Document name: 210687-EDGE-XX-XX-CO-C-0002_UU RESPONSE[P01]

Re: Salesbury View, Wilpshire – Application 3/2025/0801 UU consultation ref DC/25/3013

EDGE Consulting Engineers have provided this document as response to United Utilities planning consultation comments dated 11th December 2025. UU have requested further information pertaining to their apparatus due to concerns over their strategic water main. They state *“it is unclear whether sufficient distance and protection is provided to our strategic water main.”*

Drawing Title
**DRAINAGE LAYOUT
SHEET 1**

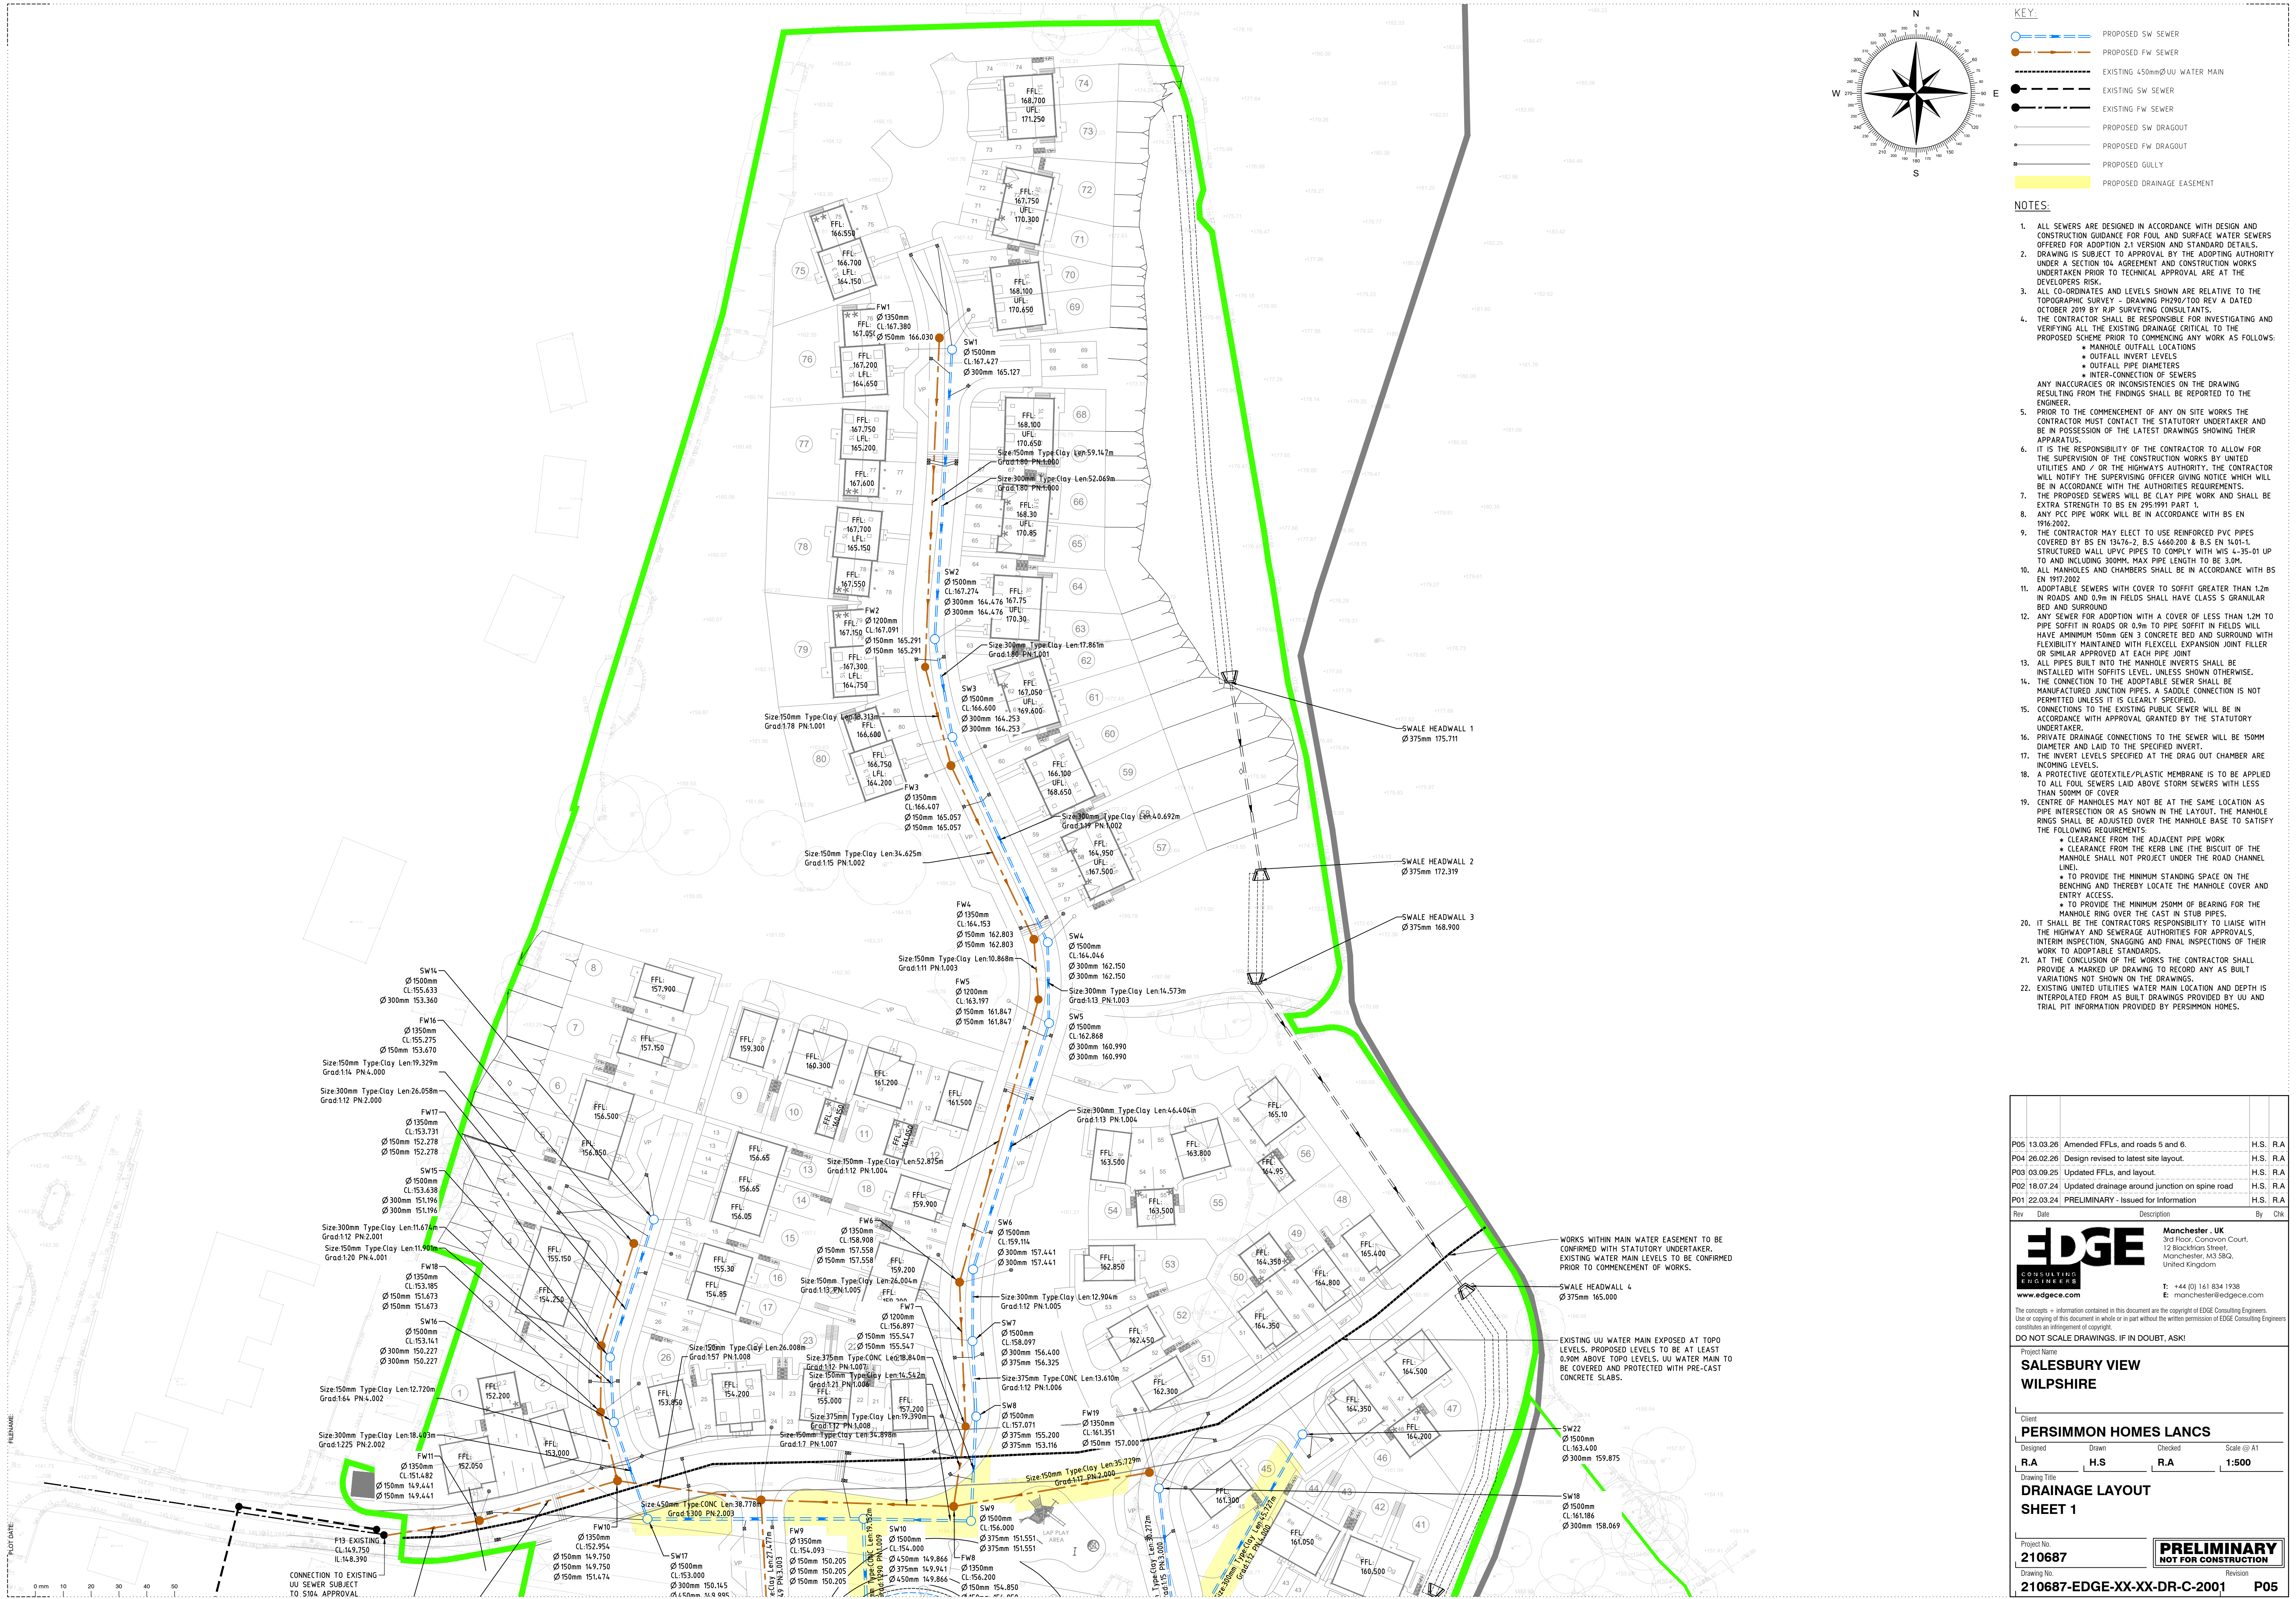
Therefore, its proximity to any development on the site should be confirmed.

The location of the main was confirmed through site excavations and liaison with United Utilities. UU themselves provided as built records of the mains installation so there is confidence on its location and proximity to any development.

The proposed development layout therefore has full consideration of the main and does not impact/ clash or negatively affect United Utilities asset. Please see enclosed associated investigations and as built drawings for clarity. We trust this answers United Utilities concerns and allows the objection to development to be lifted.
